Subject: RE: Mermaid and Playbox

DRAWING TITLE :			
PROPOSED DWELLING			
PROJECT TITLE :			
SITE OF: 'MERMAID & PLAYBOX' SEA ROAD BOGNOR REGIS PO22 7AW			
SCALE : 1:100	JOB NO.	DWG NO.	REV.
SHEET : A1	190 : 1 : B		
DATE : AUGUST 2019			
 DEANPARKMAN architecture ARCHITECTURAL CONSULTANT & SURVEYOR Corner House, 68-70 Lugley Street, Newport, Isle of Wight, PO30 5ET tel: 01983 523709 mob: 07729778111 e-mail: dean@deanparkman.co.uk www.deanparkman.co.uk

SITE OF: 'MERMAID &
PLAYBOX'
SEA ROAD
BOGNOR REGIS
PO22 7AW

SOUTH ELEVATION - BOGNOR REGIS PROMENADE

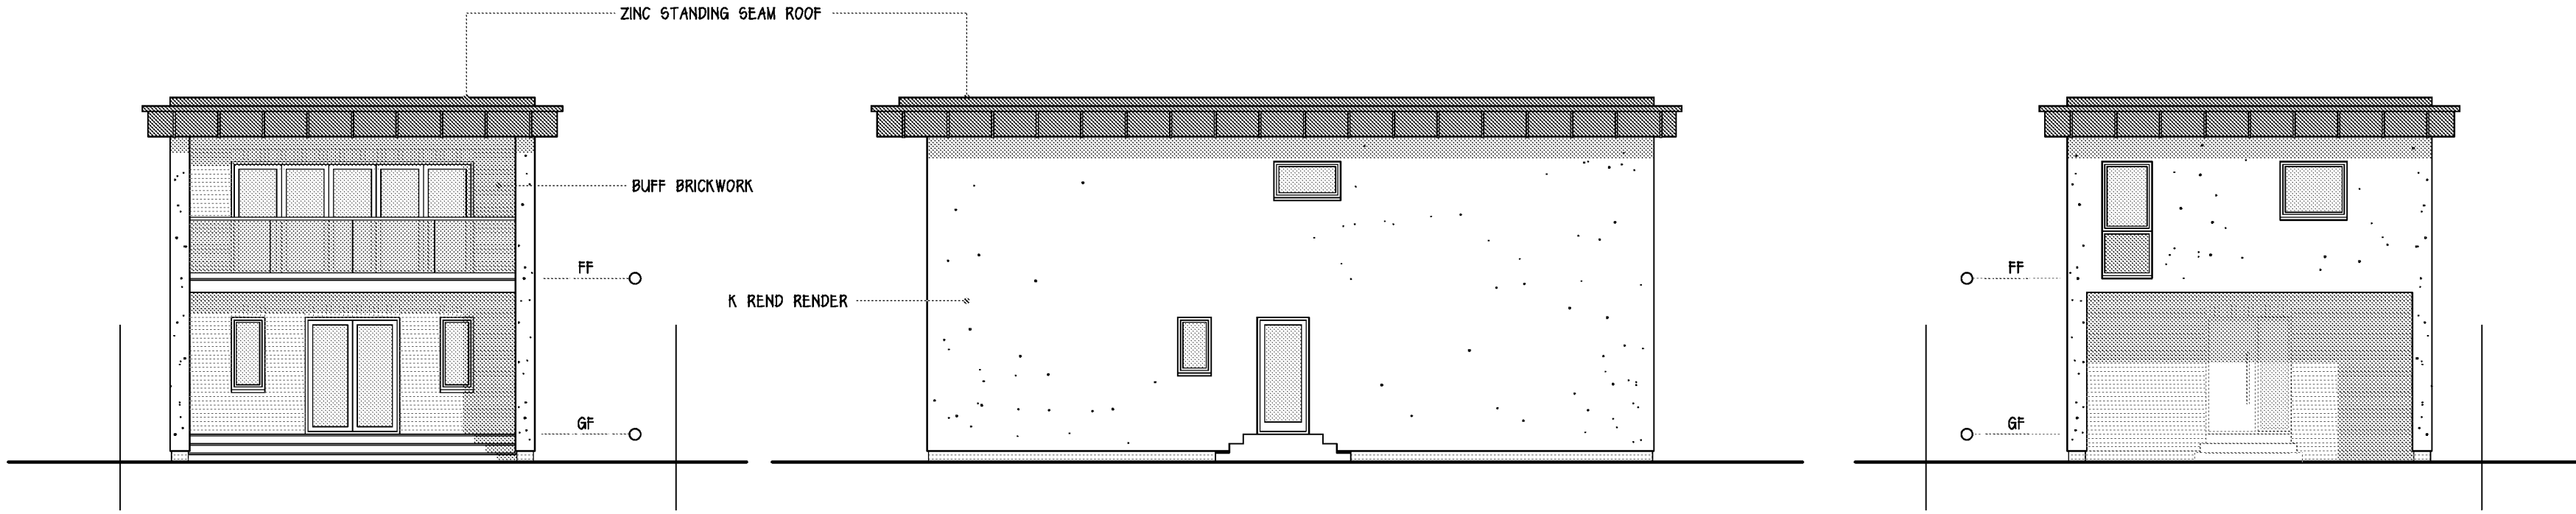
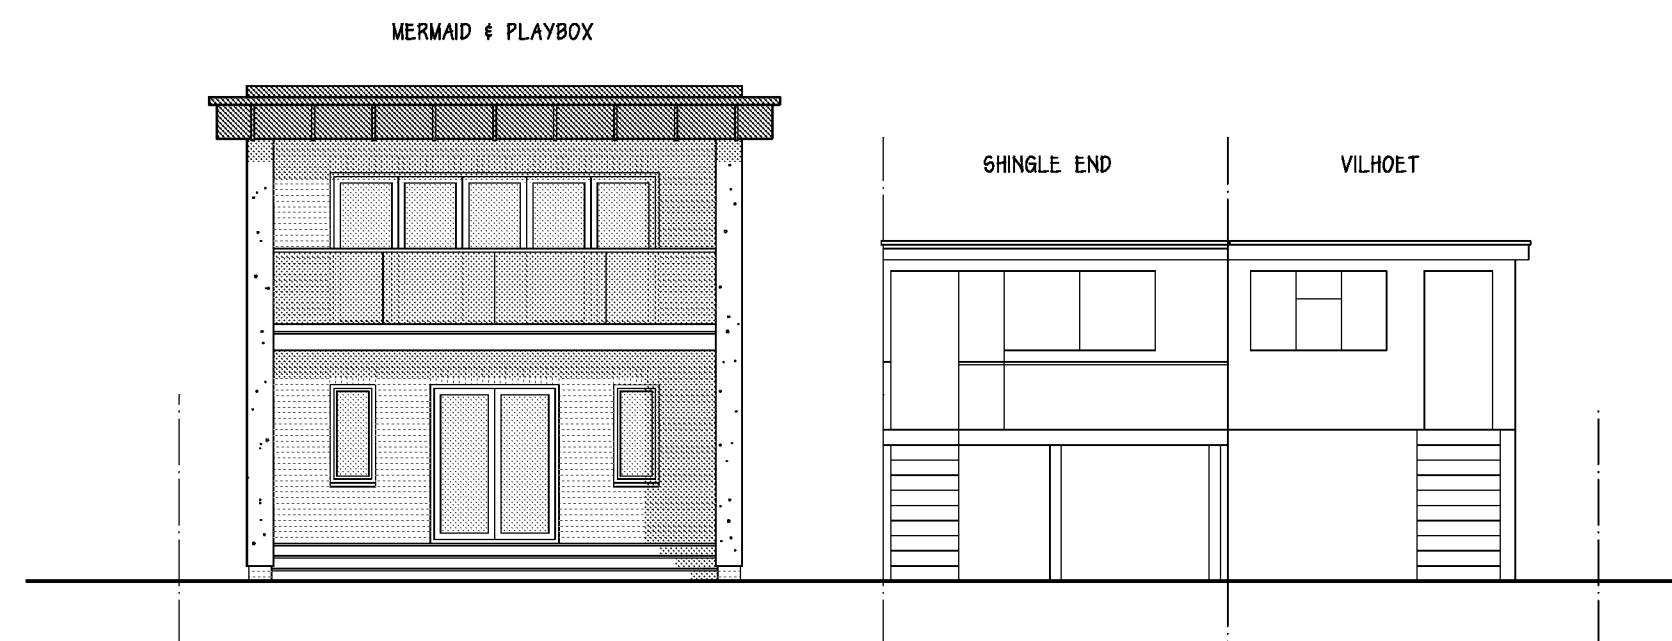
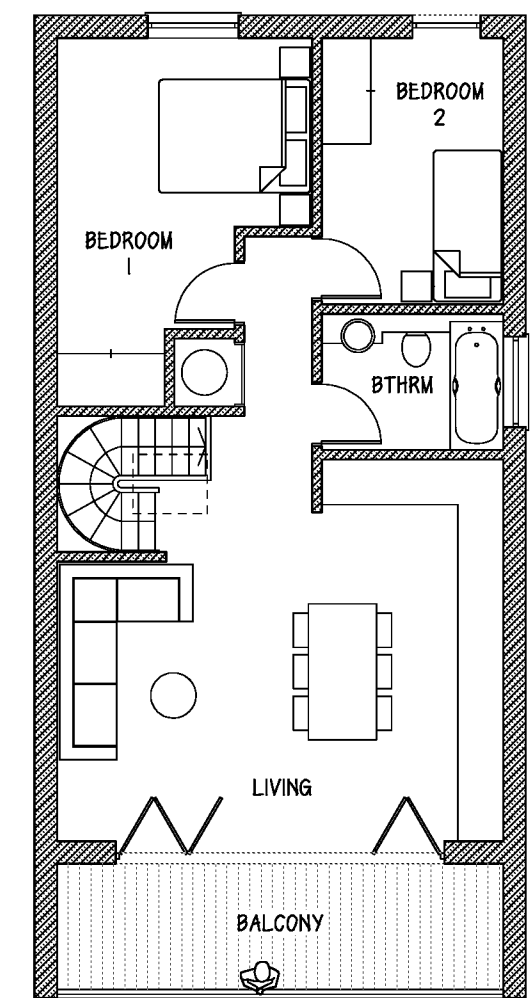
matters they have raised. Secondly a street scene showing the relationship of the proposed dwelling with the 2 adjoining smaller single storey dwellings is considered essential. This is essential as Officers consider that the proposal could have a detrimental impact on the adjoining, single storey dwellings and as such any approval would be on balance. Therefore a street scene would allow further assesment of the impact of the proposal on the occupiers of the adjoining dwellings. Also, Officers need to establish what, if any, building(s) were previously on site. Therefore any information you might have regarding this would be welcomed.

Please find attached Flood Risk Assessment Addendum and a copy of the updated drawings including street scene as requested.
